26 May 2021
Ref 19090

ST LUKE'S GRAMMAR SCHOOL
PROPOSED SENIOR SCHOOL CAMPUS & SPORTS CENTRE (SSD-10291)
TRAFFIC & PARKING MATTERS
RESPONSE TO SUBMISSIONS

I refer to your letter dated 18 March 2021 (TfNSW Reference: SYD19/00495/06, DPIE Reference: SSD 10291) addressed to DFP Planning Pty Ltd requesting additional information in respect of the abovementioned development proposal.

DRAWING TITLE
 STAGE 2 DROP-OFF & PICK-UP AREA
 B99 VEHICLE & TOYOTA COASTER
 ADDRESS
 No.800 Pittwater Road,
 Dee Why

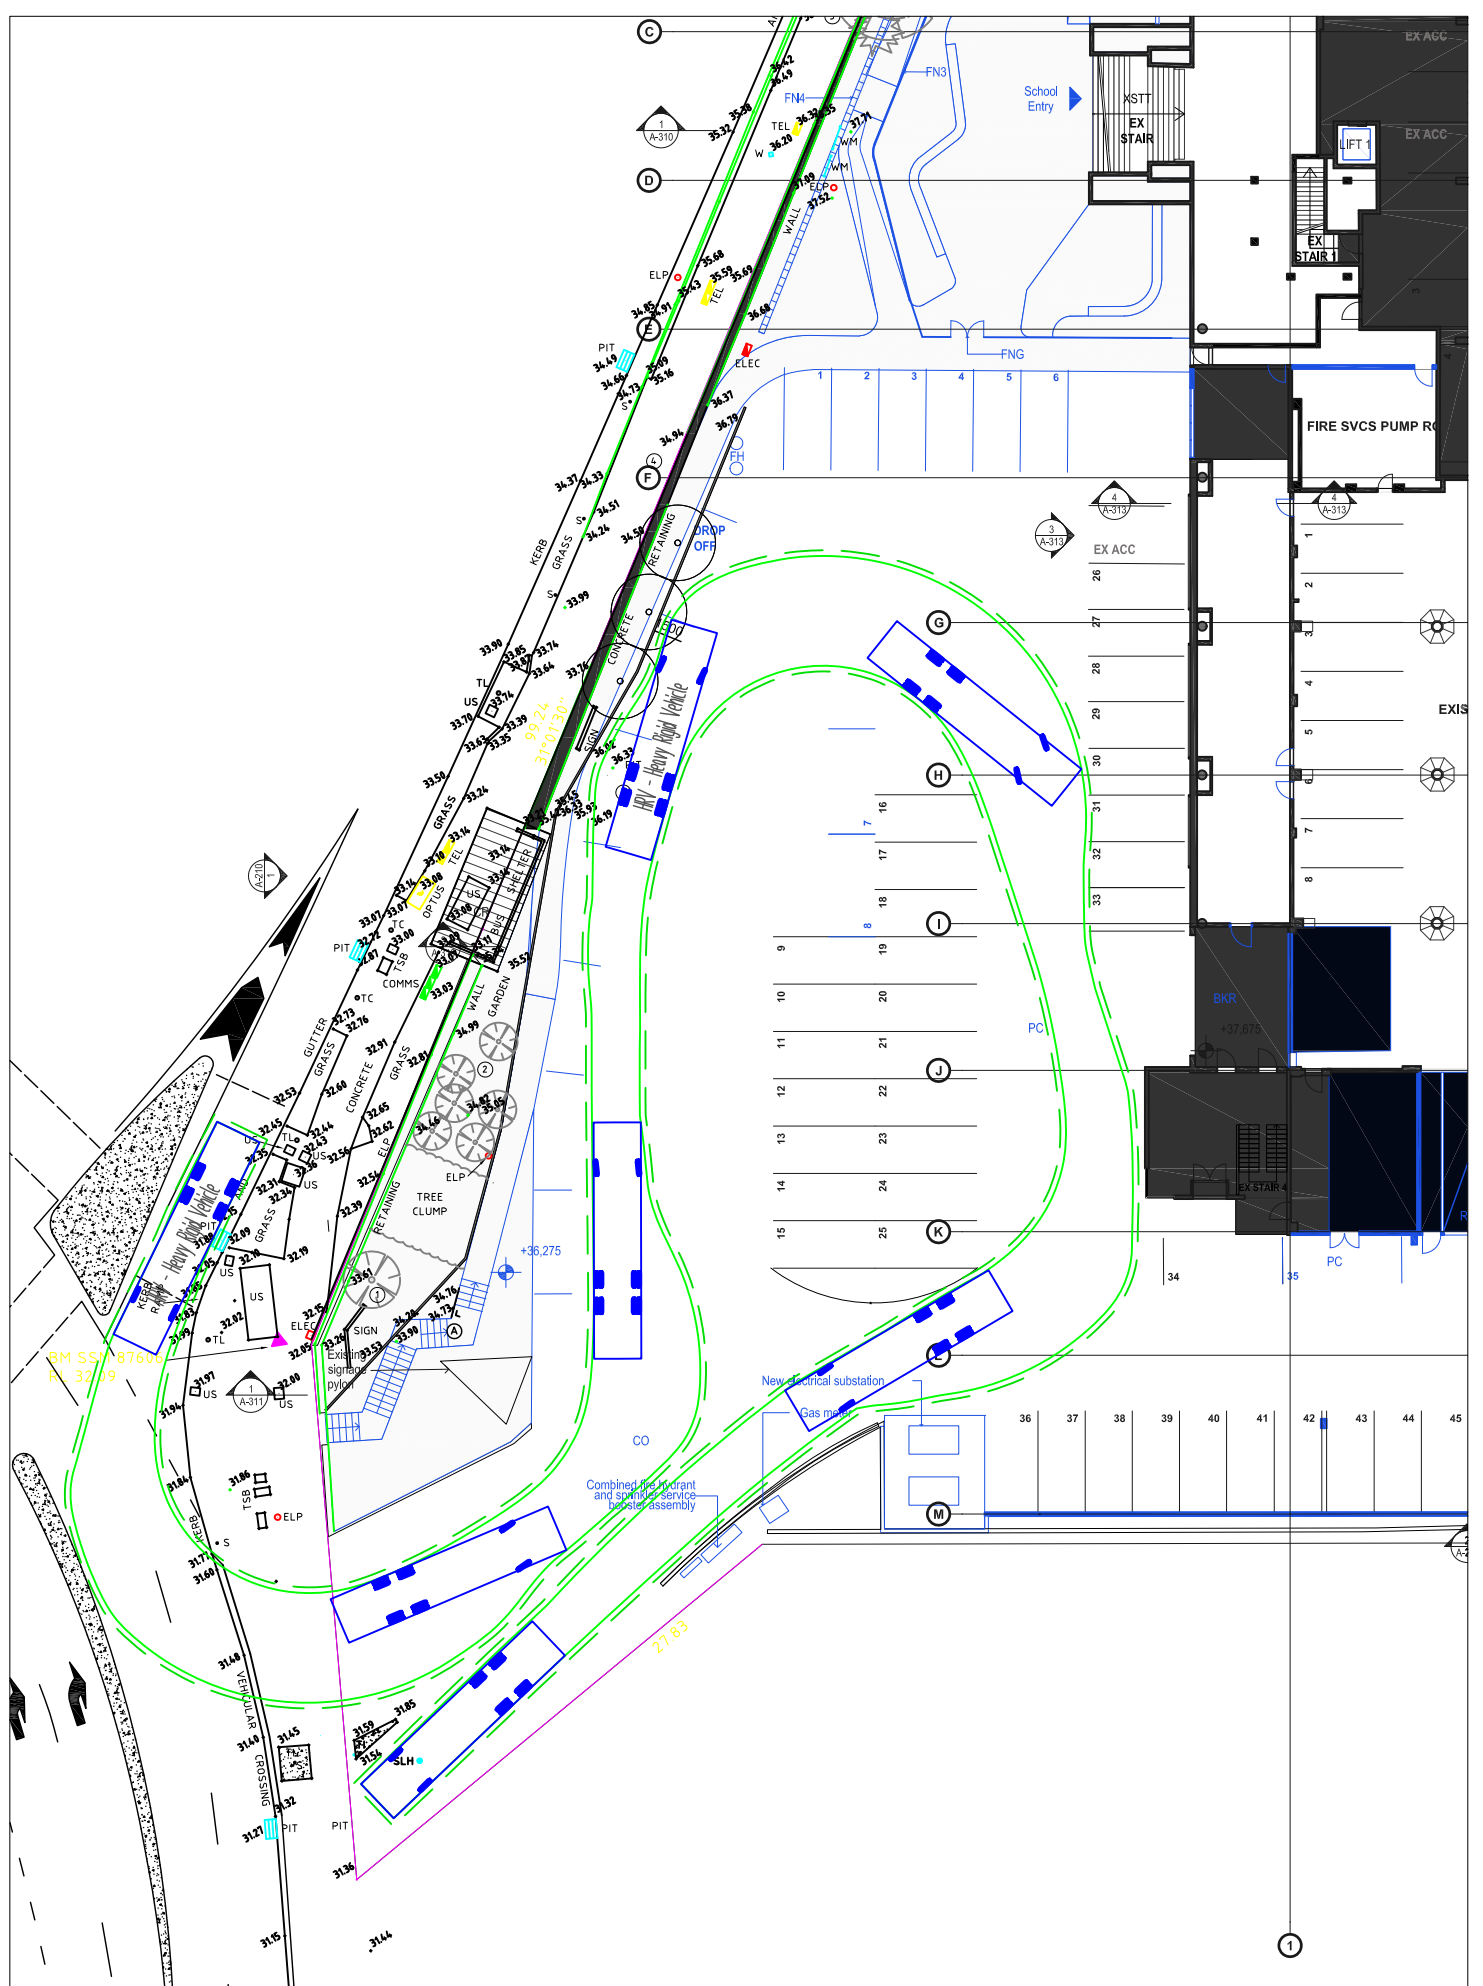
1. *The queuing analysis undertaken for the proposed pick-up and drop-off activities in the RtS needs to be updated to address the following matters:*
 - *The queuing analysis has not included the vehicles queuing to access the off street car park;*

- The queuing analysis assumes that 70 secs would be adequate to pick up each student. This would only be possible if each student would be ready to be picked up as soon as the vehicle arrived. If some of the students arrive late to the pick up area, cars need to wait longer than 70 secs and block other vehicles to enter the site. This would cause queuing on to public roads; and*

A separate traffic lane/access route is provided on the driveway to the off-street car park, clear of the drop-off/pick-up bay, as indicated on Figures 12 & 13 below.

- there are two entry lanes and one exit lane (existing and proposed) on the driveway off Harbord Road. This can be confirmed by site inspection
- the “red” and “green” cars shown on Figures 12 & 13 below are located within the proposed drop-off/pick-up bays, clear of the car park entry lane
- the “red” cars are actual projected maximum drop-off/pick-up demands, based on the surveys of existing demands extrapolated to the projected increase in enrolments in Stages 2 and 3
- the “green” cars indicate spare capacity within the drop-off/pick-up bays

- the “**yellow**” cars demonstrate that even if these “**yellow**” cars queued on the driveway beyond the drop-off/pick-up bay, they could do so *without* blocking traffic flows in or out of the car park.

Detailed queuing analysis of the drop-off/pick-up bay (see Item 4 under the “Traffic Generation” heading below) has confirmed that the *Senior School* peak drop-off/pick-up demand will be only **2 cars** upon completion of Stage 3, as indicated by the “**red**” cars in the diagrams below.

In any event, it is clear that the proposed drop-off/pick-up facility could accommodate substantially more than the projected peak demands without impeding access to the off-street car parking area in any way.

It is therefore proposed to provide staff supervision with 3 staff members (shown as red figures) as illustrated on Figures 12 and 13, consistent with the existing arrangements for the *Senior School* at the existing campus.
